Application by Oaklands Farm Solar Limited for an Order Granting Development Consent for Oaklands Farm Solar Park

The Examining Authority's first written questions and requests for information

Issued on 16 July 2024

Drawing Title: ALC Grade

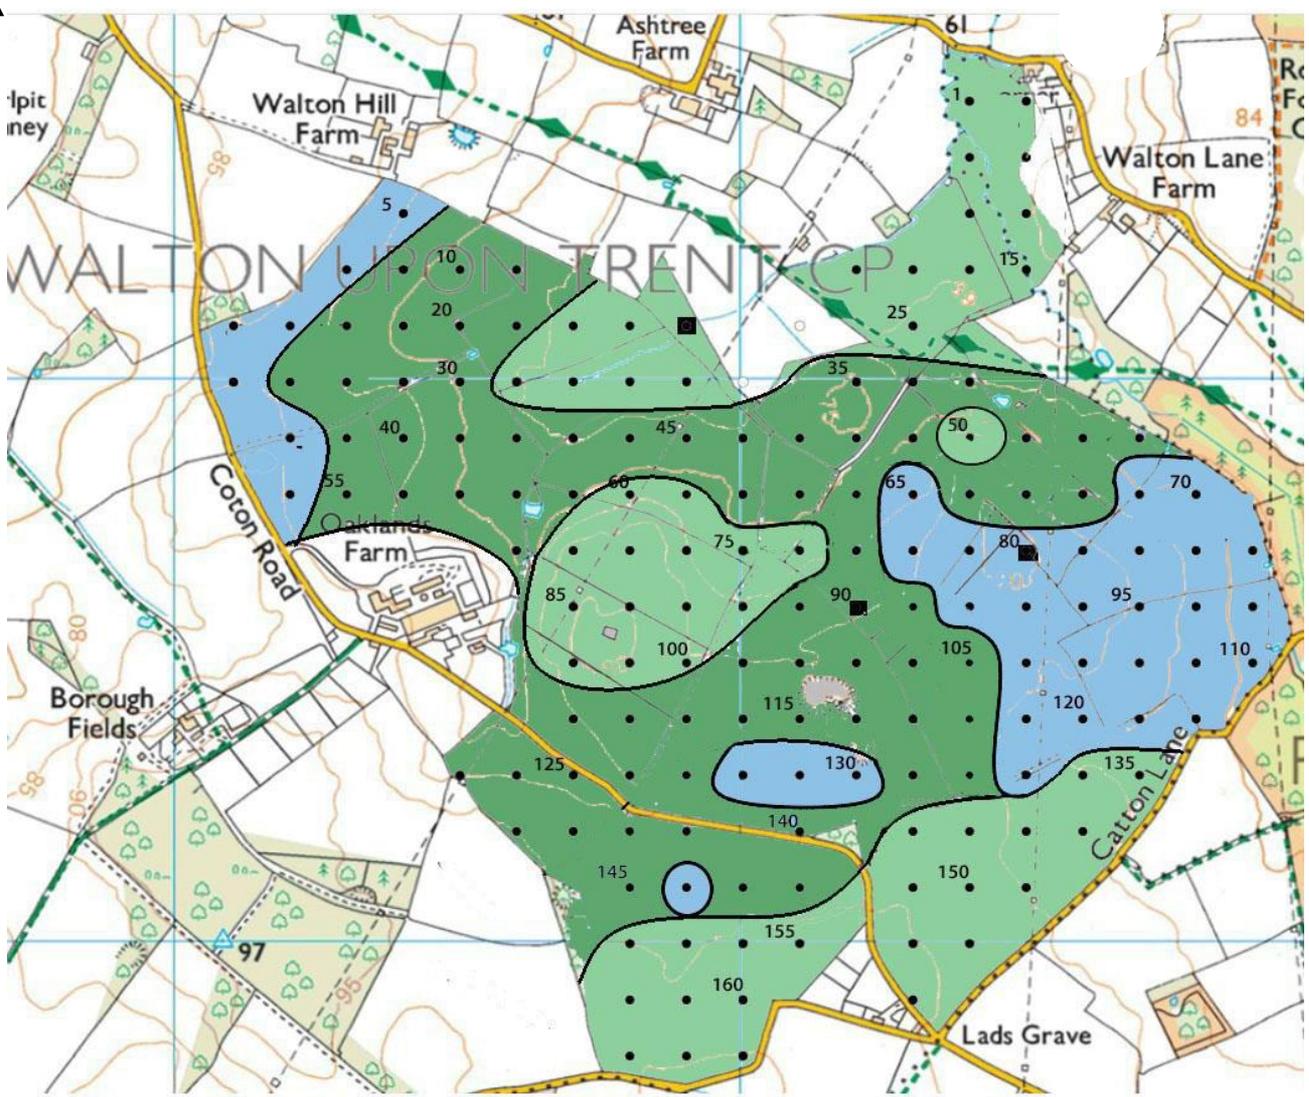
Ref:	Question to:	Question:
6.2	NE SDDC	<p><u>Agricultural Land Classification (ALC)</u></p> <p>Paragraph 2010.33 of NPS EN-3 states that the ALC is the only approved system for grading agricultural quality in England and, if necessary, field surveys should be used to establish the ALC grades in accordance with grading criteria and identify the soil types to inform soil management at the construction, operation, and decommissioning phases in line with the DEFRA Construction Code.</p> <ul style="list-style-type: none"> a) Are NE and SDDC content with the Applicant's ALC and surveys [APP-168, APP-169, APP-170, APP-171]? b) Is Subgrade 3b a robust worst case assumption for the areas that were not surveyed [APP-168]? c) Should surveys be required of areas that were not surveyed to rule out that they could be BMV agricultural land?

6.6	Applicant SDDC	<p><u>Potential permanent loss of agricultural land</u></p> <p>The Applicant [APP-169 paragraph 15.134] states that the Battery Energy Storage System and onsite substation would be removed during decommissioning, but that the land in these areas may not be restored back to the same ALC grade. The Battery Energy Storage System and substation would be within a small field of mixed Subgrade 3a and 3b quality. The Applicant</p>

Ref:	Question to:	Question:
		<p>indicates that there would be a permanent loss or downgrading of 1.5ha of Subgrade 3a agricultural land if the substation was not removed or suitably restored.</p> <ul style="list-style-type: none"> a) Noting the protection afforded to BMV agricultural land, has sufficient consideration been given to measures to avoid the permanent loss of Subgrade 3a agricultural land? b) Would it be reasonable for the dDCO [AS-005] to require no permanent loss of Subgrade 3a agricultural land? If not, why not?

**Plan KCC3018/01B**  
**Auger Point Plan**

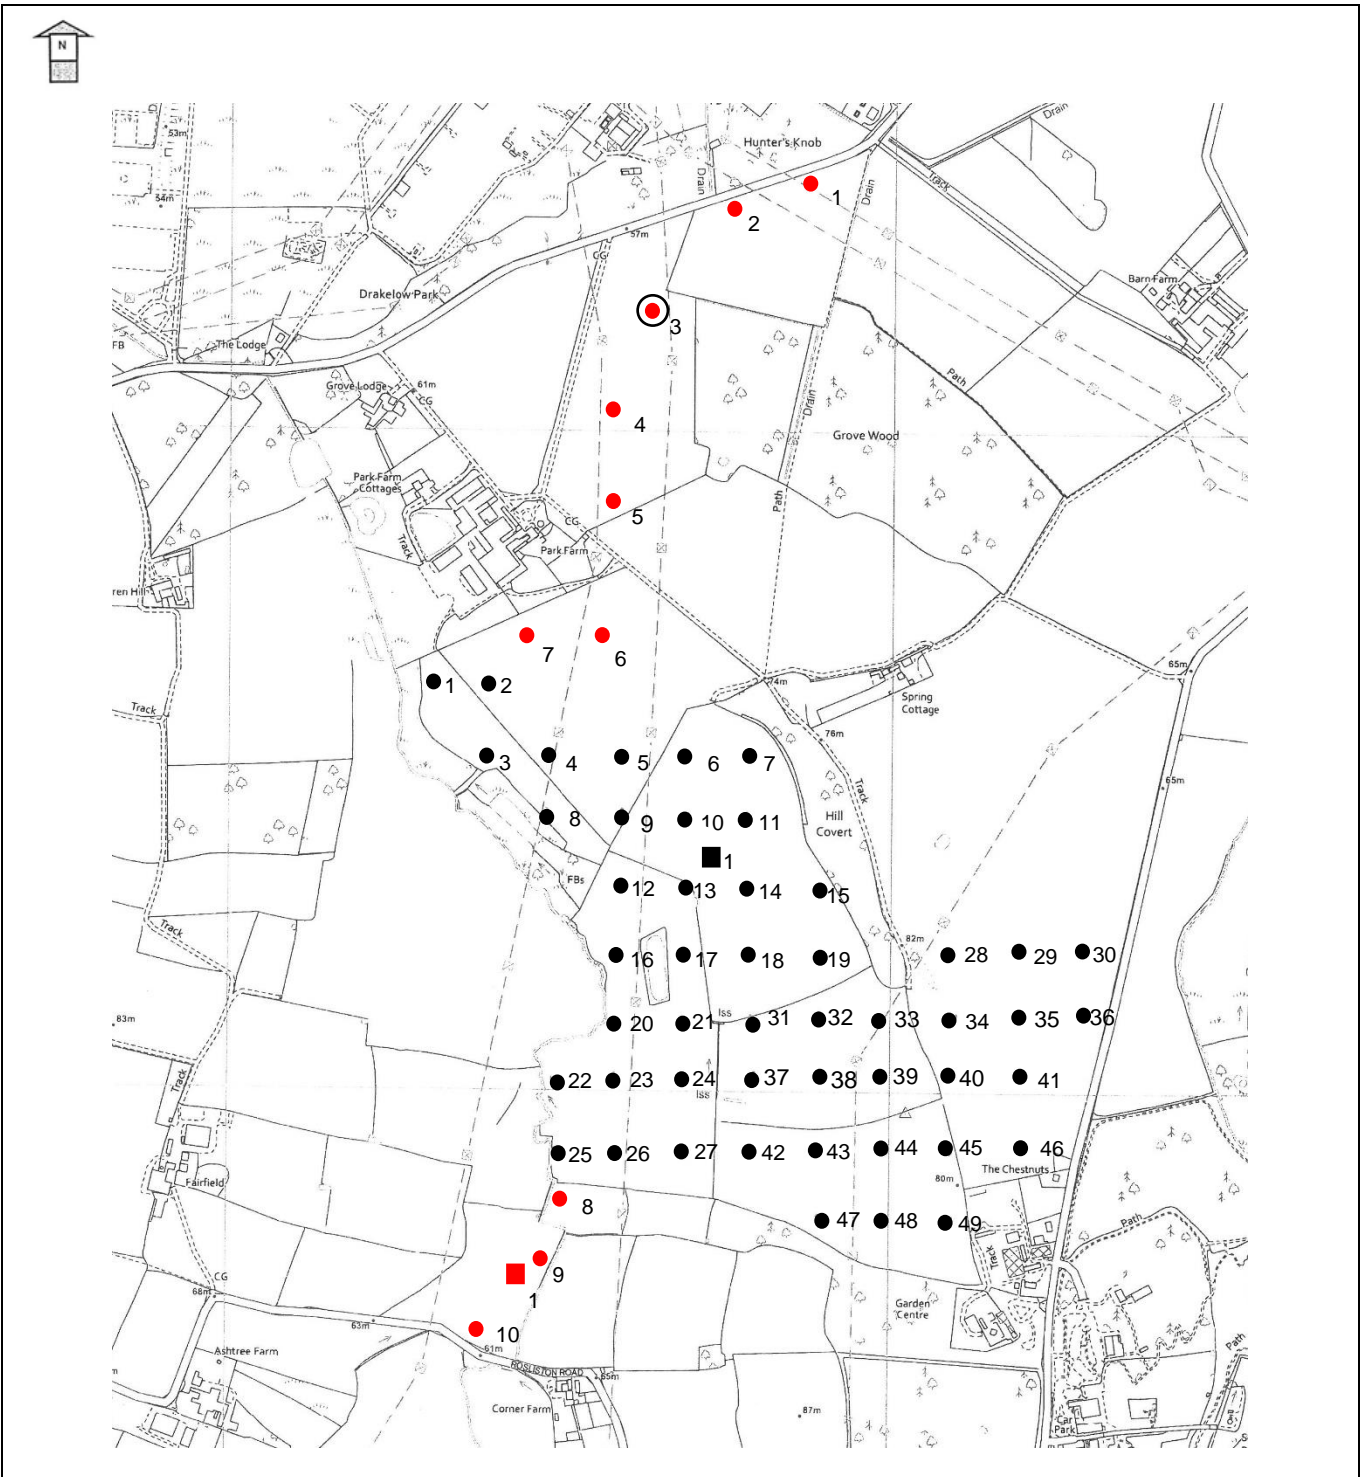
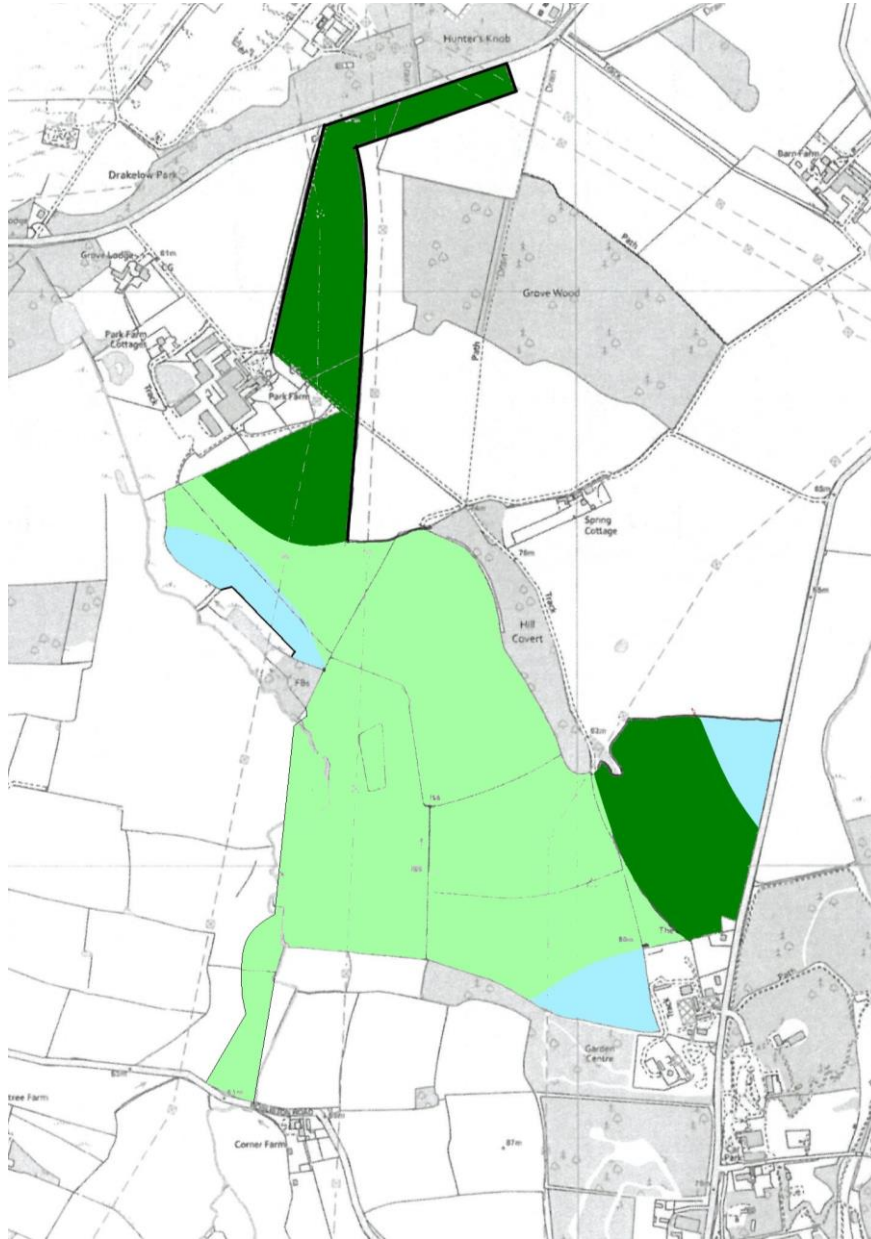
6.3	Applicant	<p><u>Park Farm and Fairfield Farm</u></p> <p>The Applicant [APP-169] focuses on the current agricultural activity and potential effects on agricultural business at Oaklands Farm.</p> <p>Please could similar descriptions and assessments be provided for Park Farm and Fairfield Farm?</p>
